Planning Consultation Request
Town and Country Planning Act 1990
APPLICATION FOR PERMISSION TO DEVELOP LAND

Application No.	2025/90578
Proposed Development:	Change of use and internal alterations of first, second and third floors to form 5 apartments (Listed Building within a Conservation Area)
Location:	Prudential House, 69, New Street, Huddersfield, HD1 2BQ
OS Map Reference	SE 414441.5748 416469.8781
Applicant/Agent:	Northern Design Partnership
Class:	Minor Developments
Site Area (sq. m):	180.0

**Consultation Response from KC,
Conservation & Design**

**Change of use and internal alterations of first, second and third floors to form 5 apartments
(Listed Building within a Conservation Area)**

SECOND FLOOR PLAN

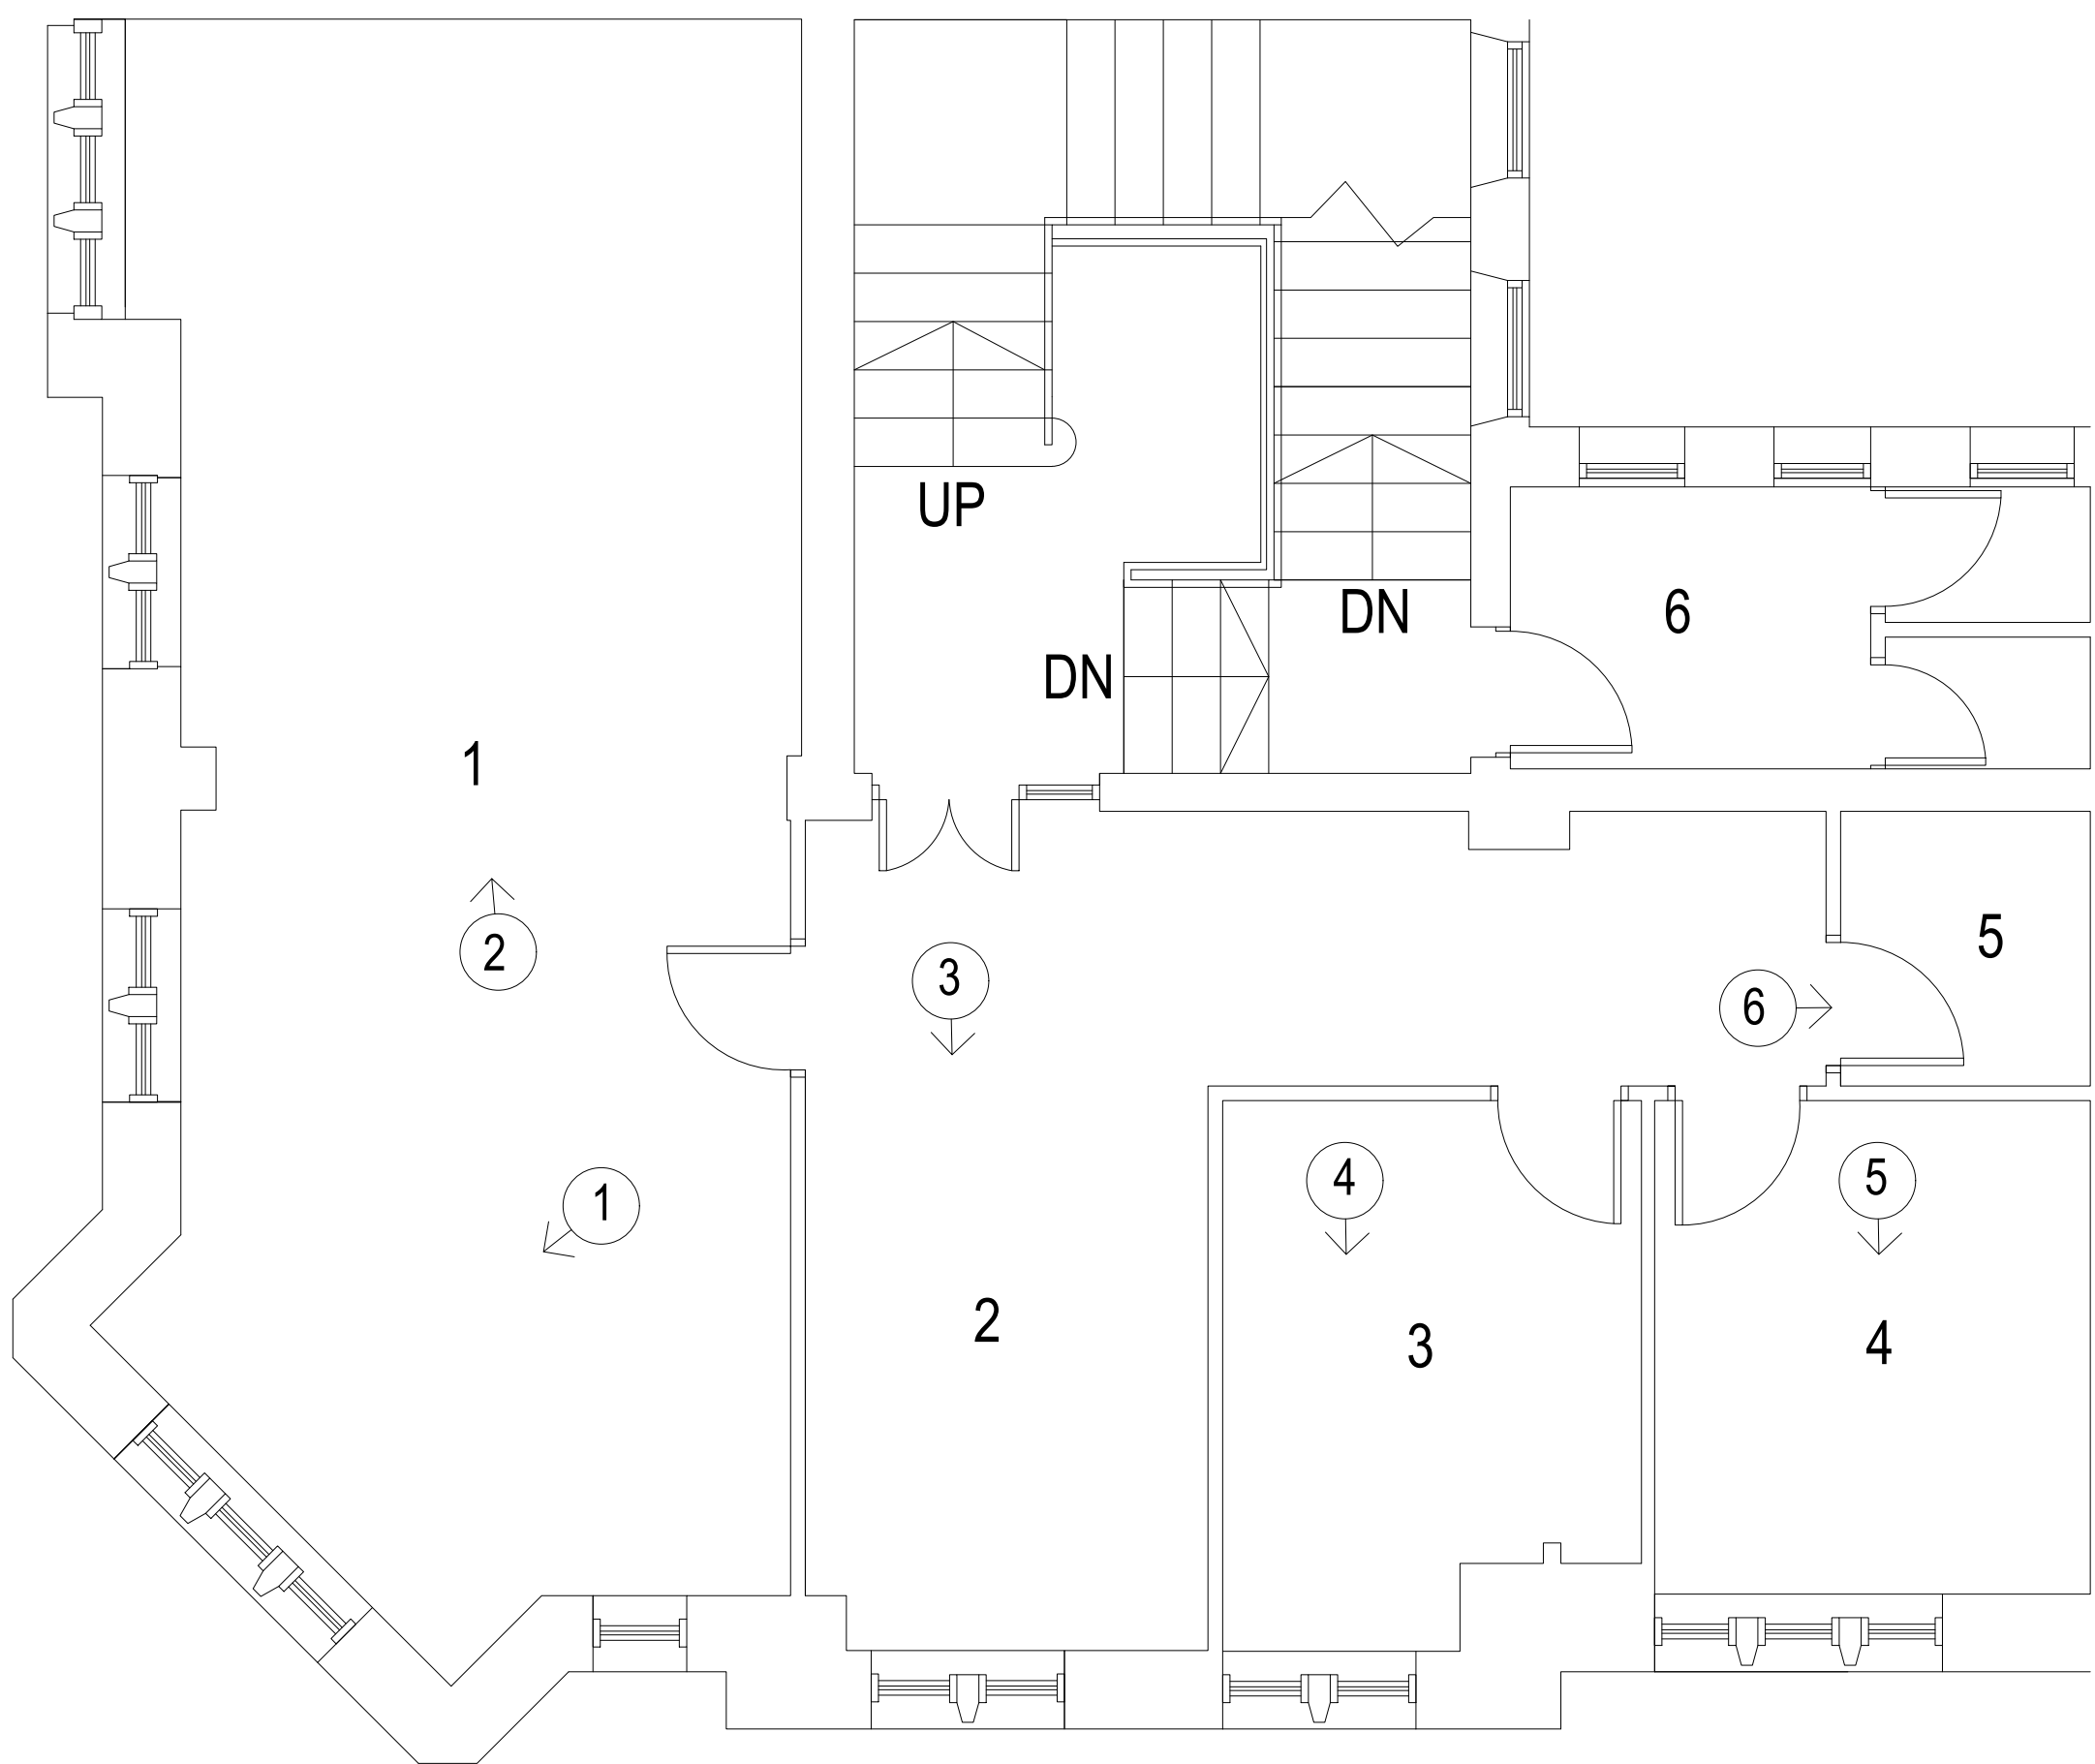
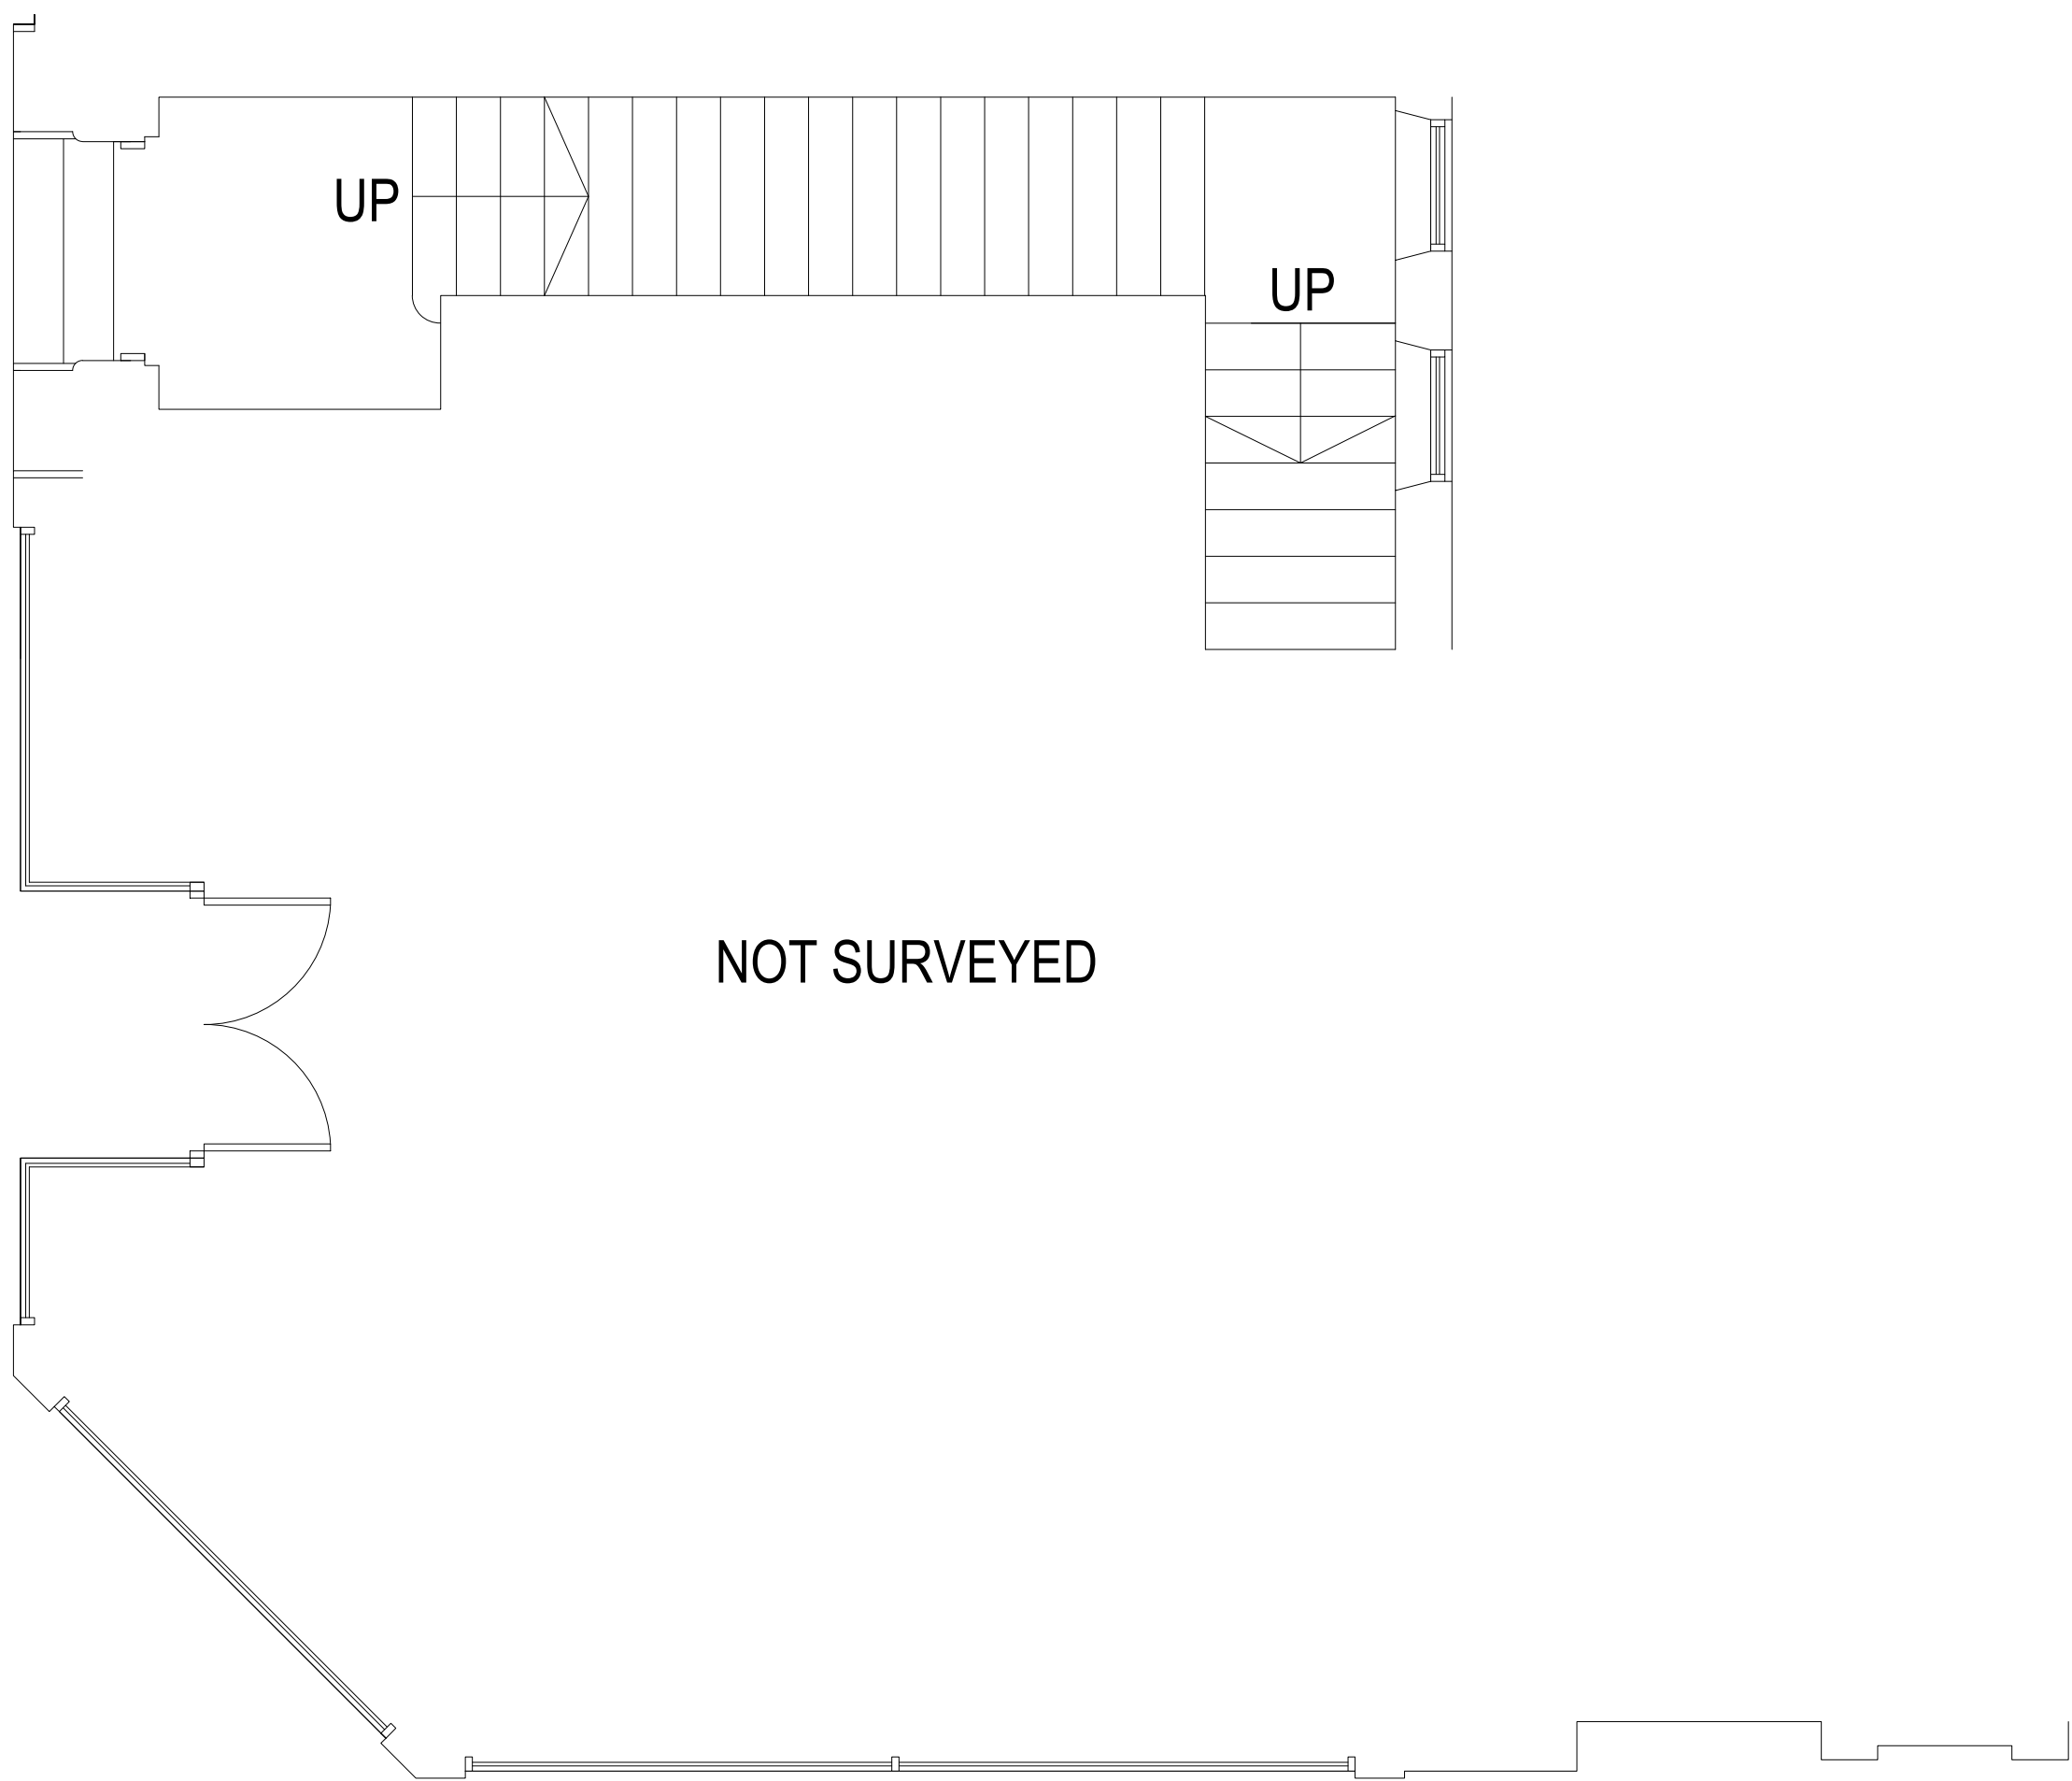
No works appear to be proposed to the staircases and the agent states that plans for the third floor indicate the fireplaces will be retained.

Where deep cornices, picture rail, deep skirting and window surrounds including areas of panelling below remain, this should be retained wherever possible.
